Further Submissions on ISH1 DCO Questions

Wheelabrator Kemsley (K3 Generating Station) and Wheelabrator Kemsley North (WKN) Waste to Energy facility Development Consent Order

PINS Ref: EN010083

**Document 10.5
March 2020 - Deadline 2**

Drawing number - 1371 SK138

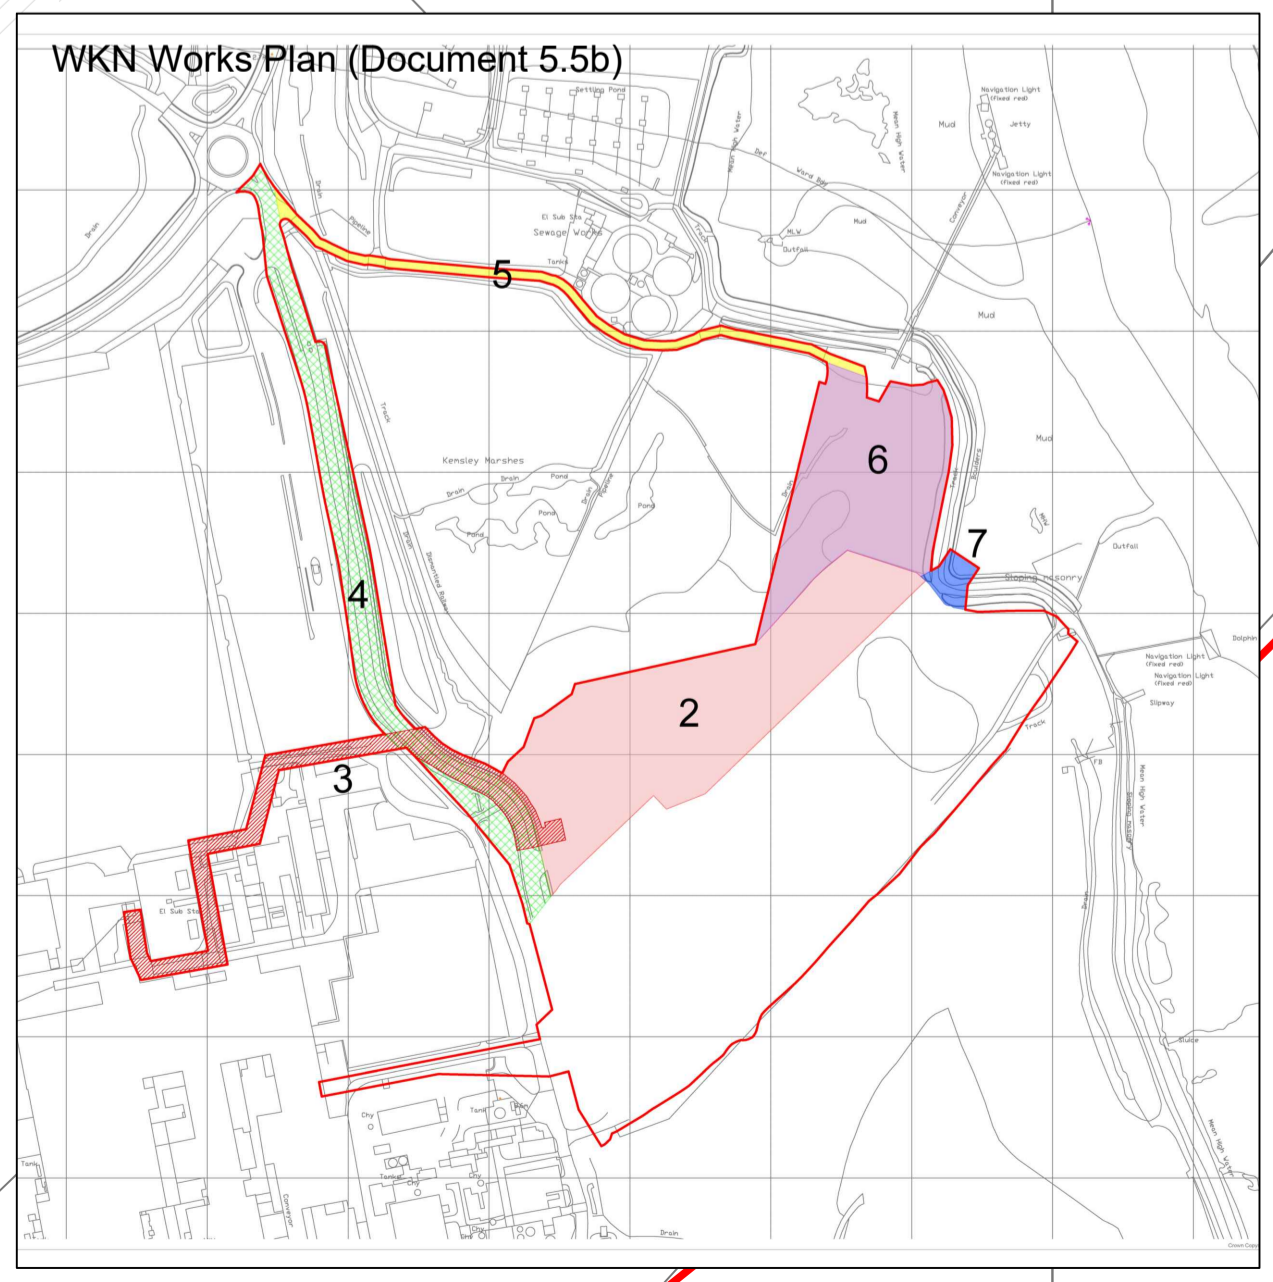
- 2. ISH:11 – Limits of Deviation & Regulation 5(2)(j)(ii)**
- Is the Applicant satisfied that all limits of deviation are shown on a works plan in accordance with Regulation 5(2)(j)(ii) of the Infrastructure Planning (Applications: Prescribed Forms and Procedure) Regulations 2009 ('APFP')?*

- 2.4 It is not necessary or desirable to fix the sub-limits of deviation within the Work Areas themselves on the works plans. These 'sub-limits' fall entirely within the Works Areas, and are regulated by Requirement 14 in order to afford a small degree of flexibility at detailed design and construction phase.

- 2.5 Accordingly the Applicant has moved the 'parameter plan' that appeared with the works plans in Article 16(c) (reference 9812-0031-07 dated September 2019) to a separate entry in Article 16 – it now appears as 16(g) WKN Parameter Plan (drawing number 9812-0031-09 dated March 2020). This is also consistent with the nomenclature that has been used throughout the Environmental Statement.
